To: [REDACTED]
Cc: [M25 Junction 28](#)
[Ashley, Charles](#)
Subject: Request for information from the Forestry Commission.
Date: 20 January 2021 10:37:52
Attachments: [TR010029-000364-20210112_2528 Written Questions_FINAL.pdf](#)

Application by Highways England for the M25 Junction 28 improvement scheme (the Proposed Development)
The Examining Authority's Written Questions and Requests for information (WQ1)
Issued on Wednesday 13 January 2021

Project Title	M25 Junction 28		
Drawing Title	FIGURE 5.1 AIR QUALITY CONSTRAINTS		
Drawing Number	Project	Originator	Volume
	HE551519 - ATK - EAQ	XX - GS - GI - 000001	
Original Size: A3	Scale: 1:25,000	Project Ref. No: --	Sheet: 1 of 1 Rev: C03

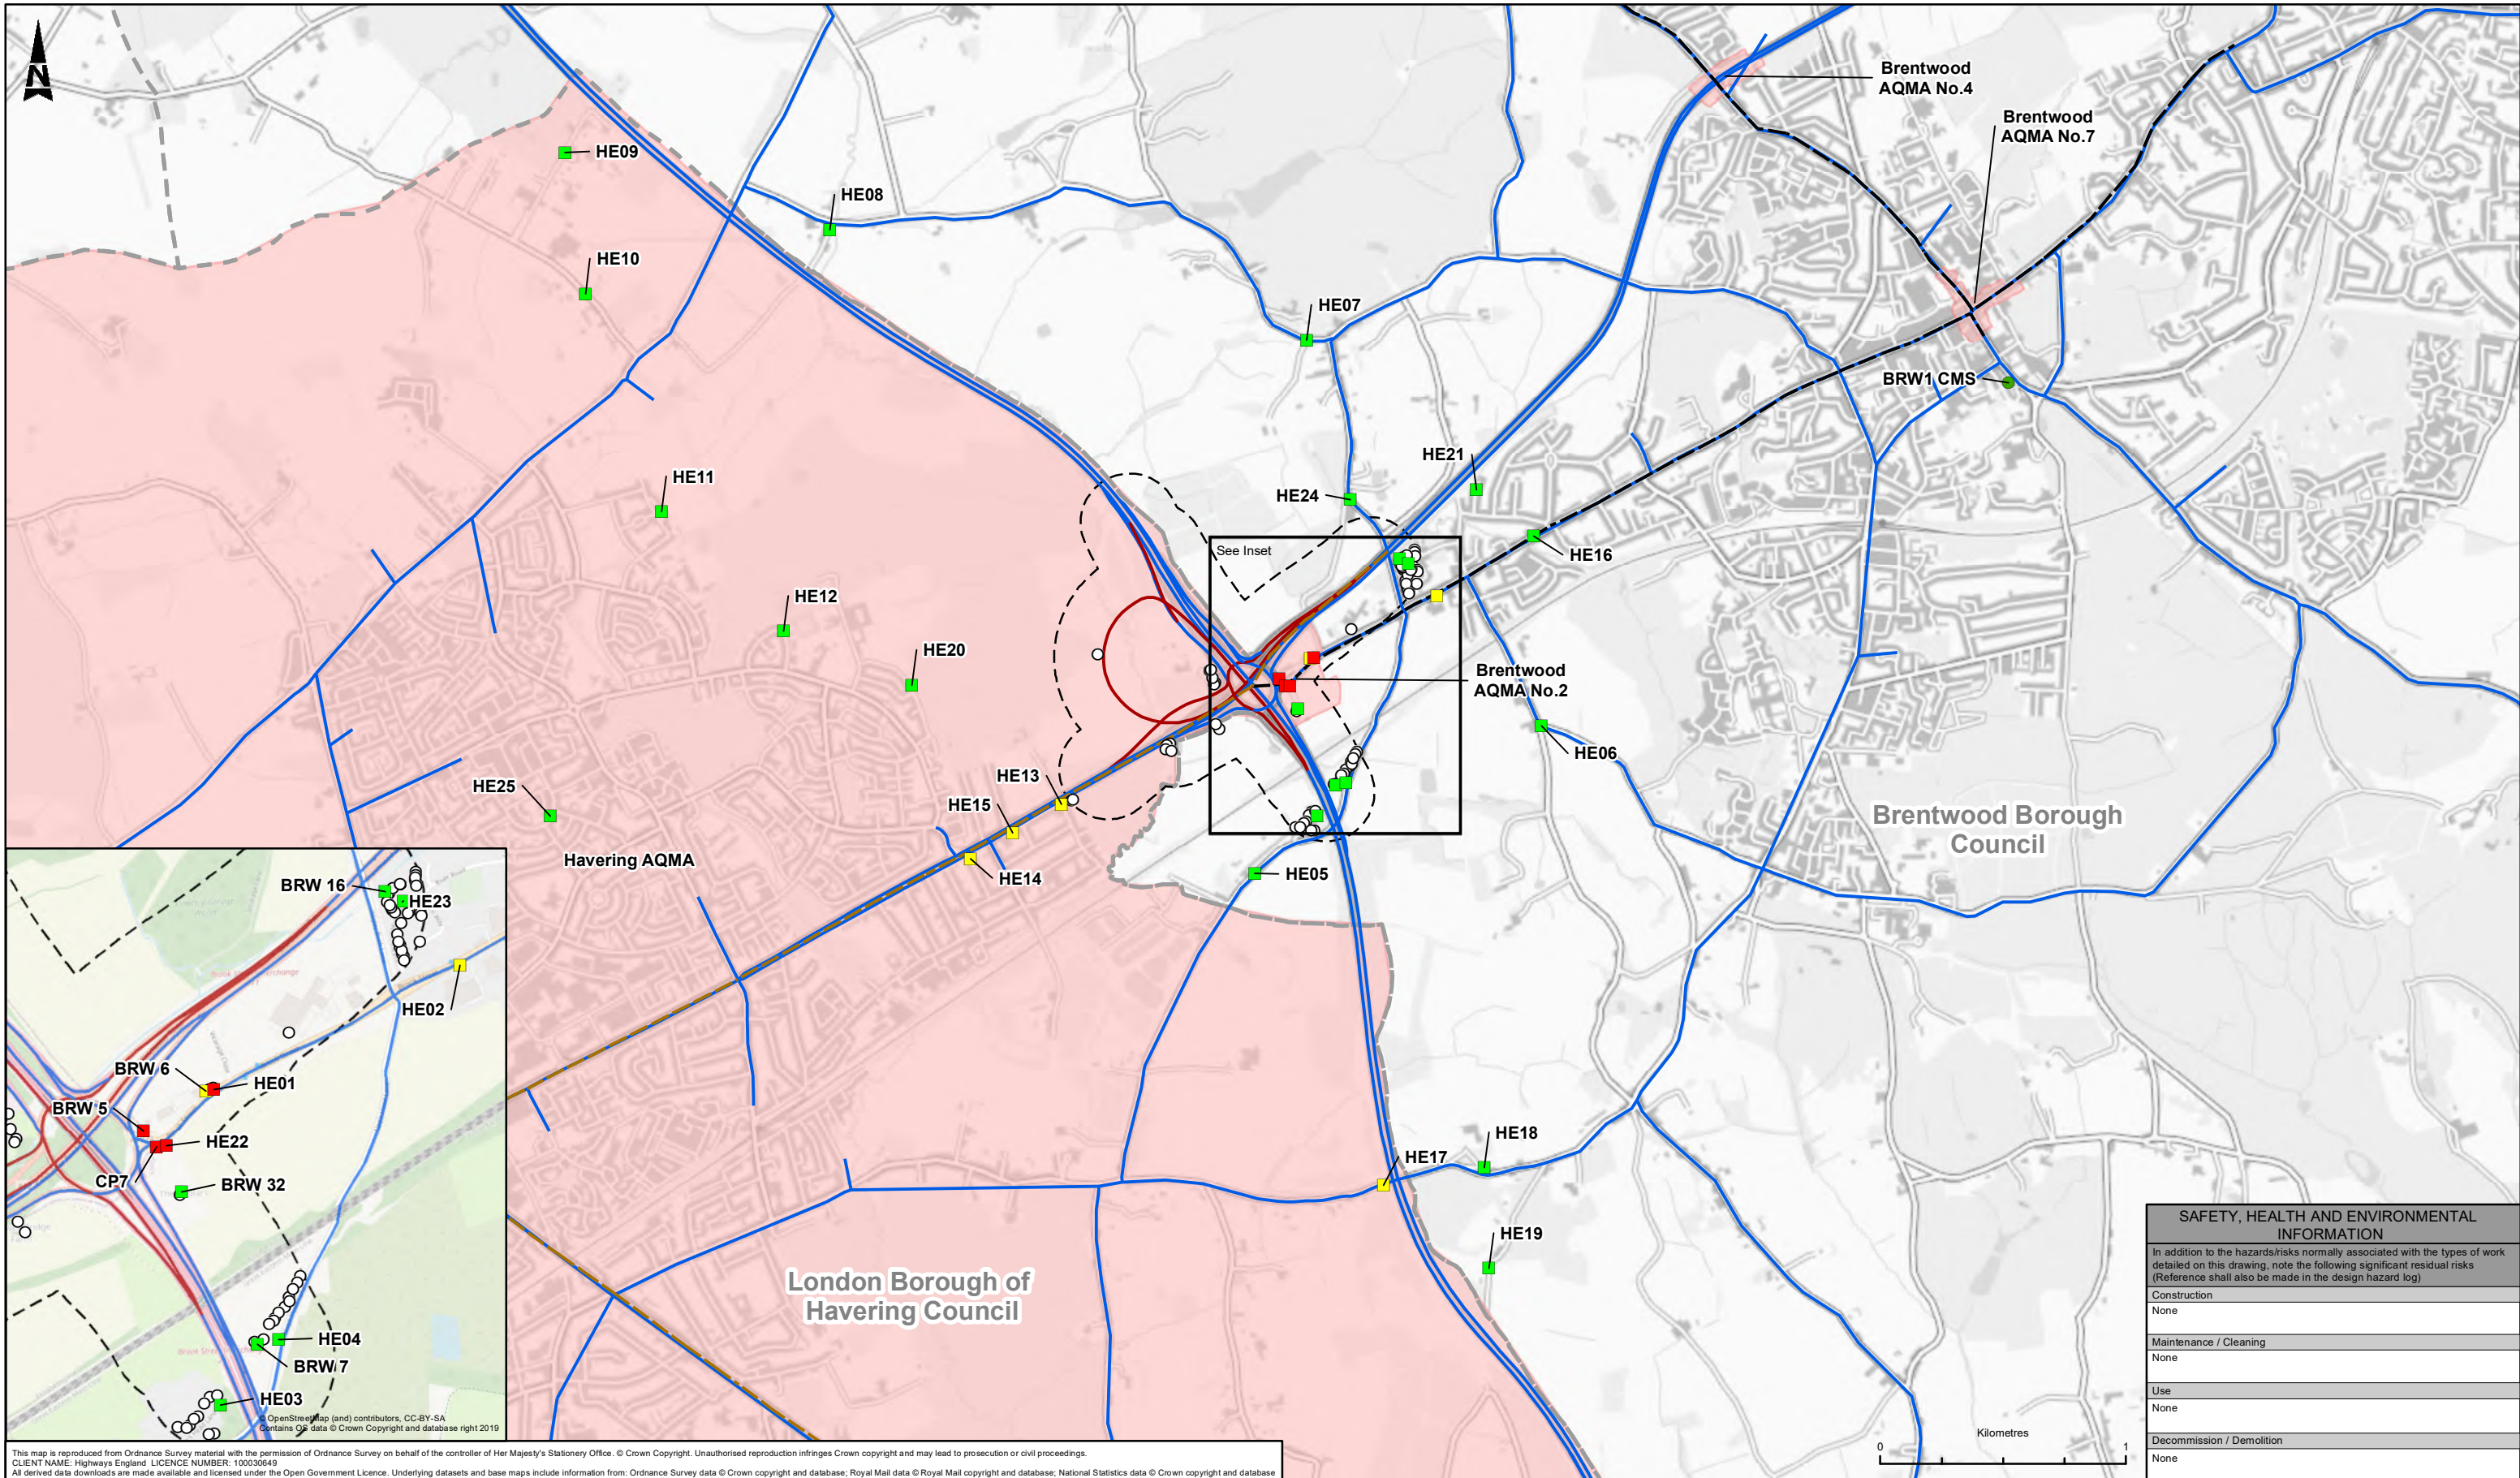
AQ 1.6	<p><i>Methodology</i> The Applicant</p>	<p>Air quality modelling has been undertaken based on IAN 170/12 v3 and is detailed in Appendix 5.1 [APP-052]. The Applicant has not explained why the monitoring stations shown on Figure 5.1 [APP-040], especially those within the Brentwood Air Quality Management Area (AQMA) which are exceeding the nitrogen dioxide (NO₂) 40ug/m³ (micrograms per cubic metre) limit have not been modelled for the 2022 operation year.</p> <p>Explain why the air quality monitoring stations shown on Figure 5.1 have not been included within the air quality model for the operation year of 2022, considering these receptors are within the Havering and Brentwood AQMA's.</p>
AQ 1.7	<p><i>Methodology</i></p>	<p>Paragraph 5.7.25 of Chapter 5 of the ES [APP-027] states that Maylands Golf Club will be included as a receptor, and Maylands Golf Club is stated to be receptor R79 in Table</p>

Project Title	M25 Junction 28
Drawing Title	FIGURE 5.2 STUDY AREA FOR CONSTRUCTION DUST ASSESSMENT
Drawing Number	HE551519 - ATK - EAQ XX - GS - GI - 000002
Original Size	A3
Scale	1:16,000
Project Ref. No.	---
Sheet	1 of 1
Rev.	C03

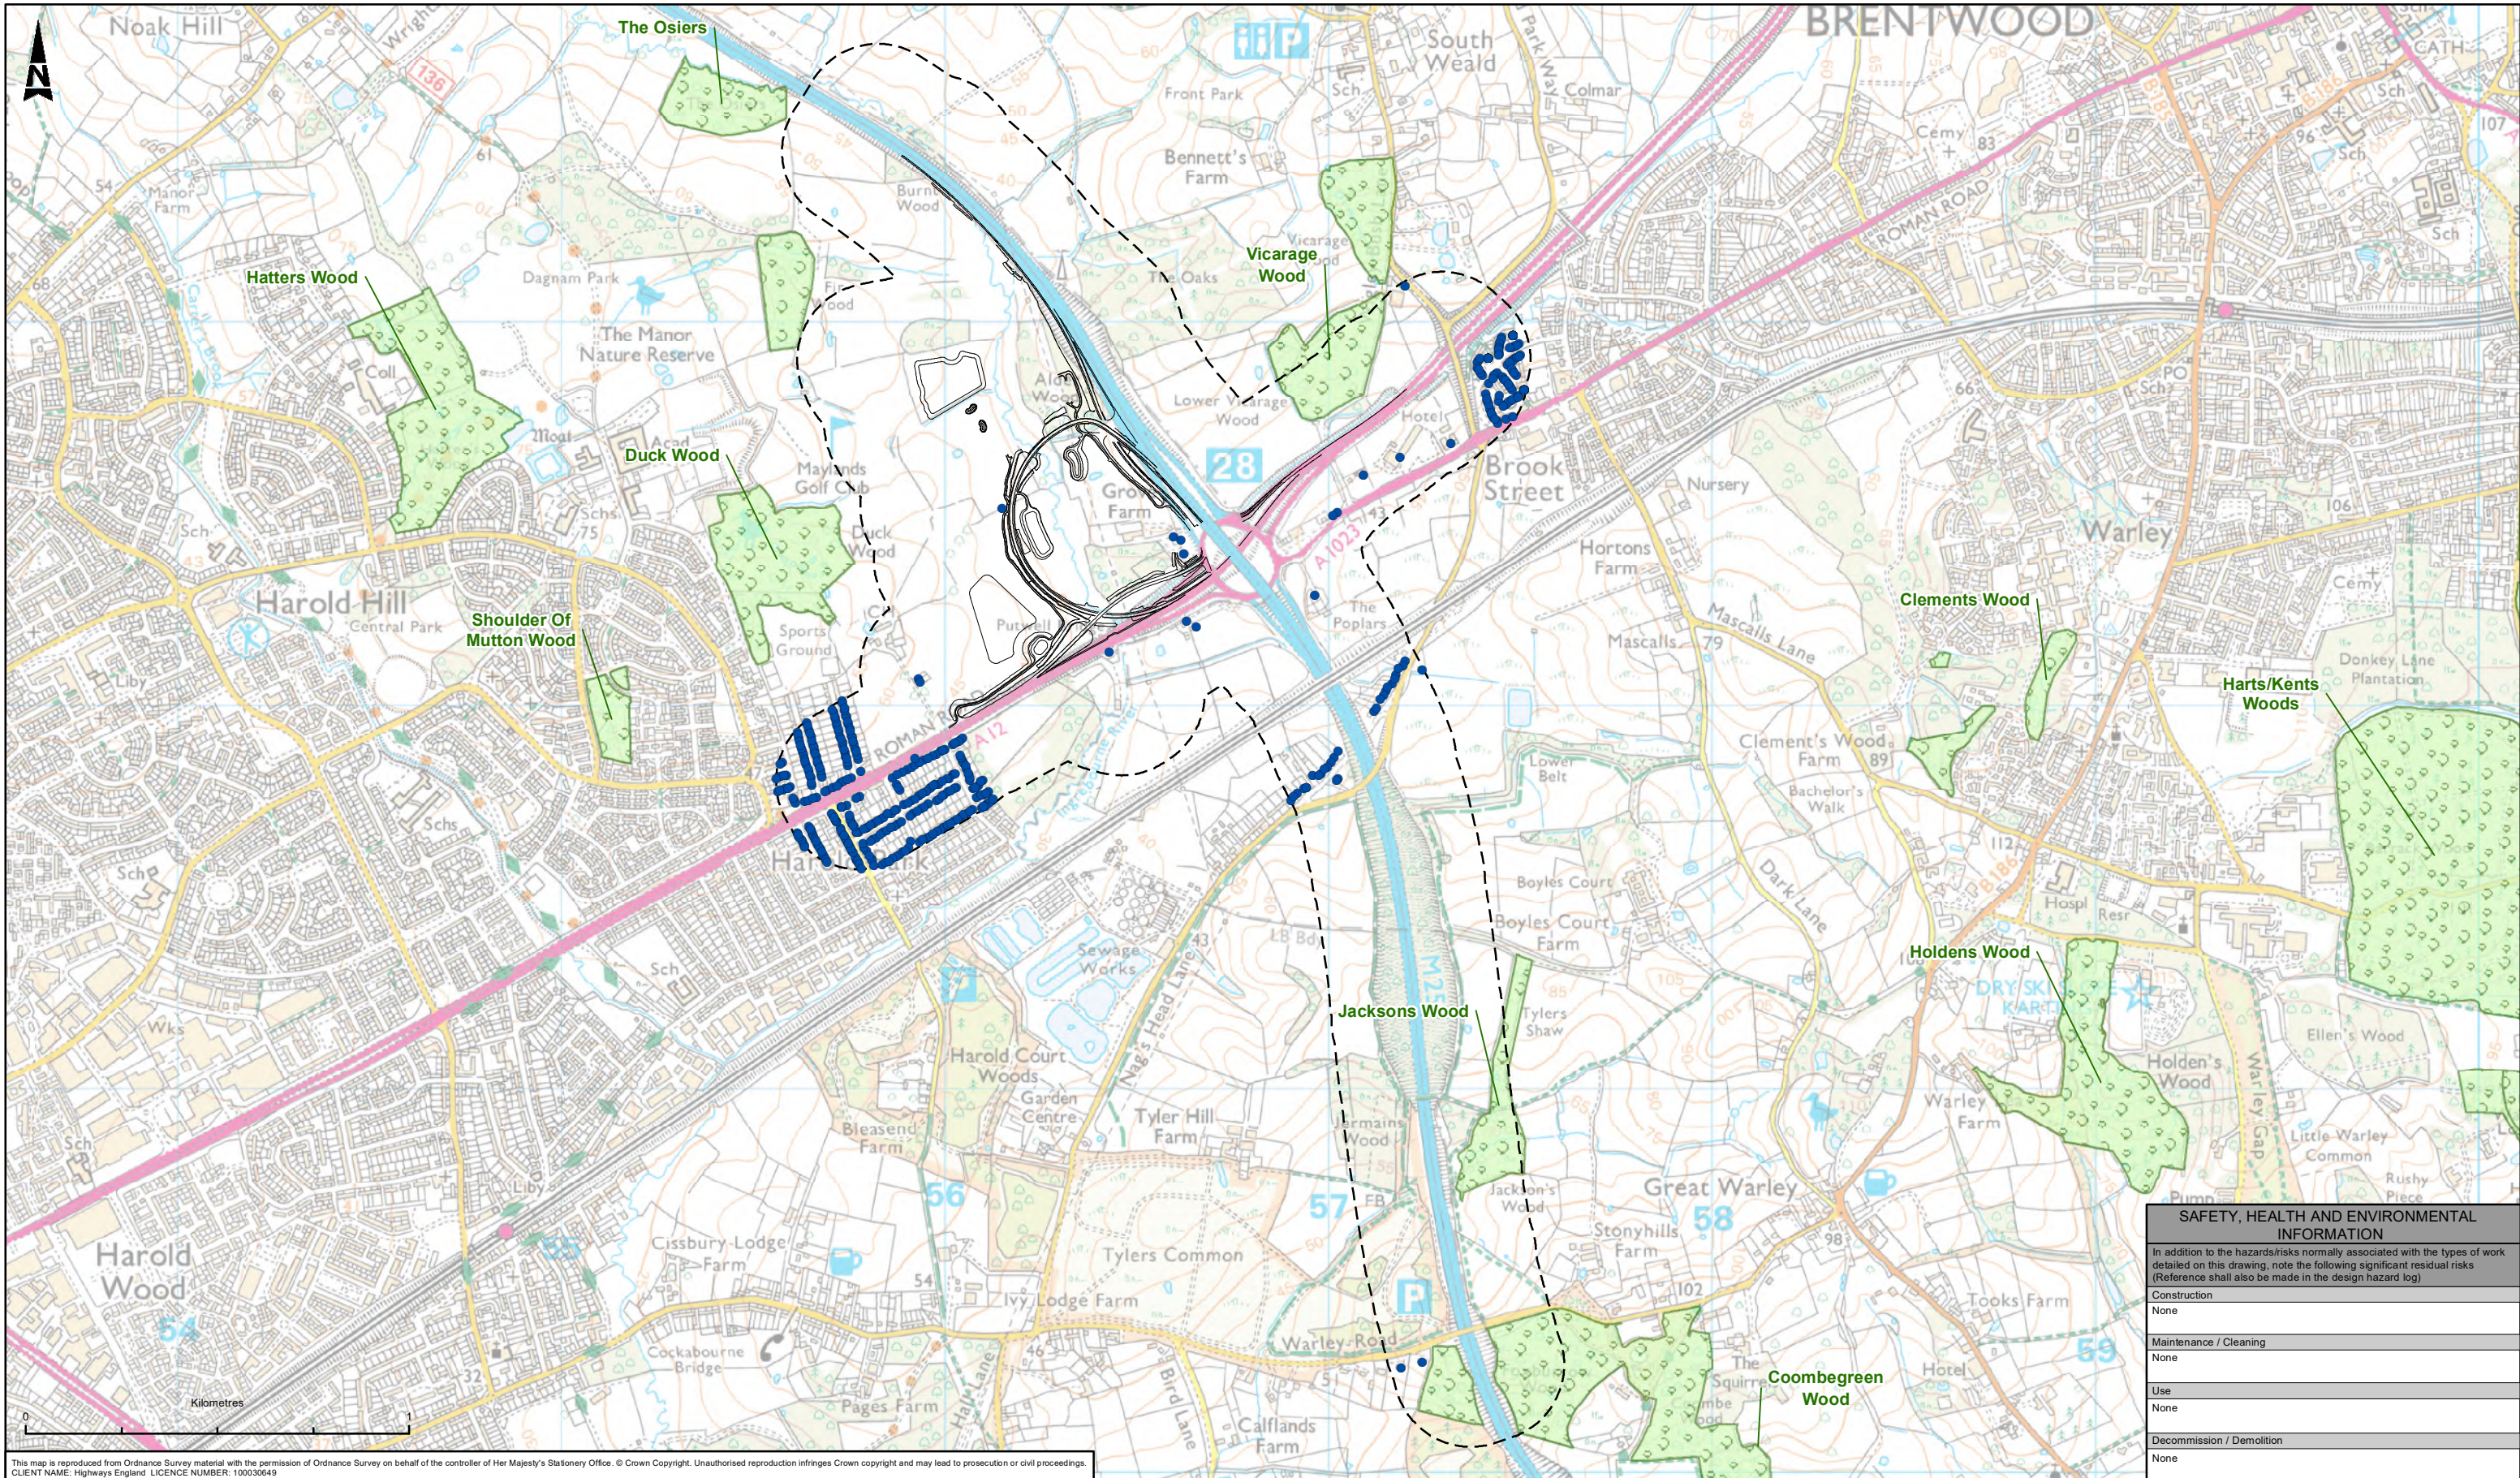
AQ	Air Quality	
AQ 1.1	<i>Baseline Assessment</i> The Applicant	<p>Figure 5.2 of the Air Quality Figures accompanying Chapter 5 of the ES [APP-040] presents receptors sensitive to construction dust and highlights the ancient woodland surrounding the site. However, some of the highlighted ancient woodlands are outside of the construction dust study area so it is unclear if these are included as receptors or not. Furthermore, Figure 5.2 does not illustrate other ecological receptors, such as Local Nature Reserves (LNR) and Local Wildlife Sites (LWS) that are within the study area. These receptors are shown on Figure 7.3 [APP-042].</p> <p>In addition to information provided within Chapter 5 of the ES [APP-027], clarify where receptors sensitive to construction dust and other ecological receptors that have been assessed are with respect to the Proposed Development, provide a figure that contains the following:</p> <ul style="list-style-type: none">- The Order limits.- The construction and dust air quality assessment study areas.- Relevant sensitive human and ecological receptors.
